Our Ref: SDNP/18/02229/ADJAUT

Neighbouring Authority Consultation

Proposal: A/40/18/OUT - Outline application with some matters reserved for the development of up to 525 residential dwellings (Class C3), 3 ha (gross) of employment land (Class B1), public open space, play areas, access, associated infrastructure and landscaping. Departure from the Development Plan.

Address: Land North of Water Lane, Angmering

Integrated Masterplan
Produced by Pro Vision, NTS.

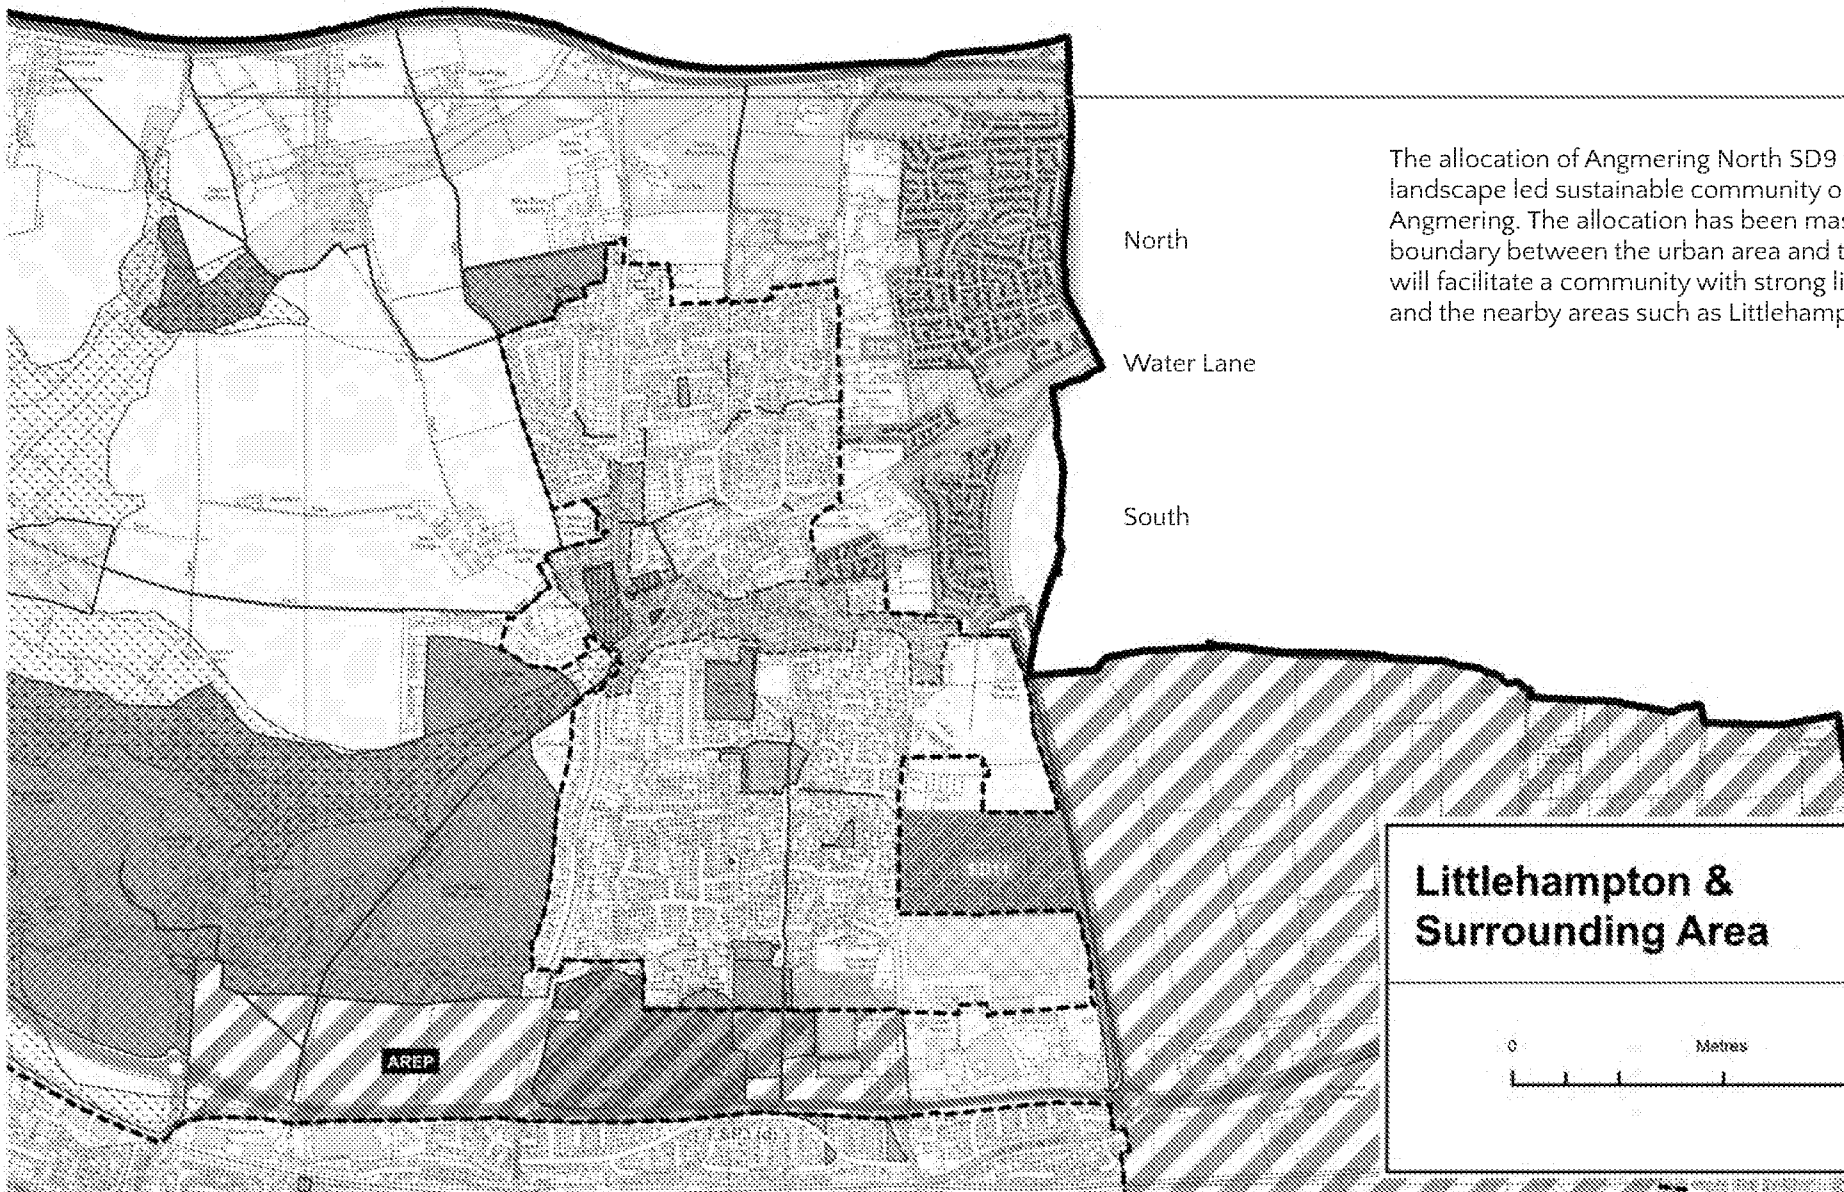
The masterplan includes a large area of open space to the north of the site. This is a significant asset for the development but does not currently appear to be suitably linked to the development, visually or physically. We also note the linear park but this does appear as a corridor rather than a useable feature tying the scheme together from north to south. Ultimately the corridor connects through to the larger area of public open space to the north through a narrow gap between houses.

The large area of public space, if well designed is likely to attract visitors, some of which will come by car, especially if it includes a junior football pitch. This needs to be factored into the scheme to avoid nuisance to residents but also the possibility of people parking on Dappers Lane which would damage the verges and detract from its increasingly rural feel.

The masterplan shows multiple LEAPS, LAPS etc dotted throughout the development including two that directly abut the large area of public open space to the north. We would suggest that it would be better to invest time and money in a better more integrated public open space including some of the play areas. Due to the proximity of the SDNP, we would also encourage the developers to think about a more 'natural' play space integrating with the landscape and changes in contours as well as making best use of the features that already exist. This is an opportunity to bring the National Park to the residents rather than creating a suburban feature on the boundary between the two areas.
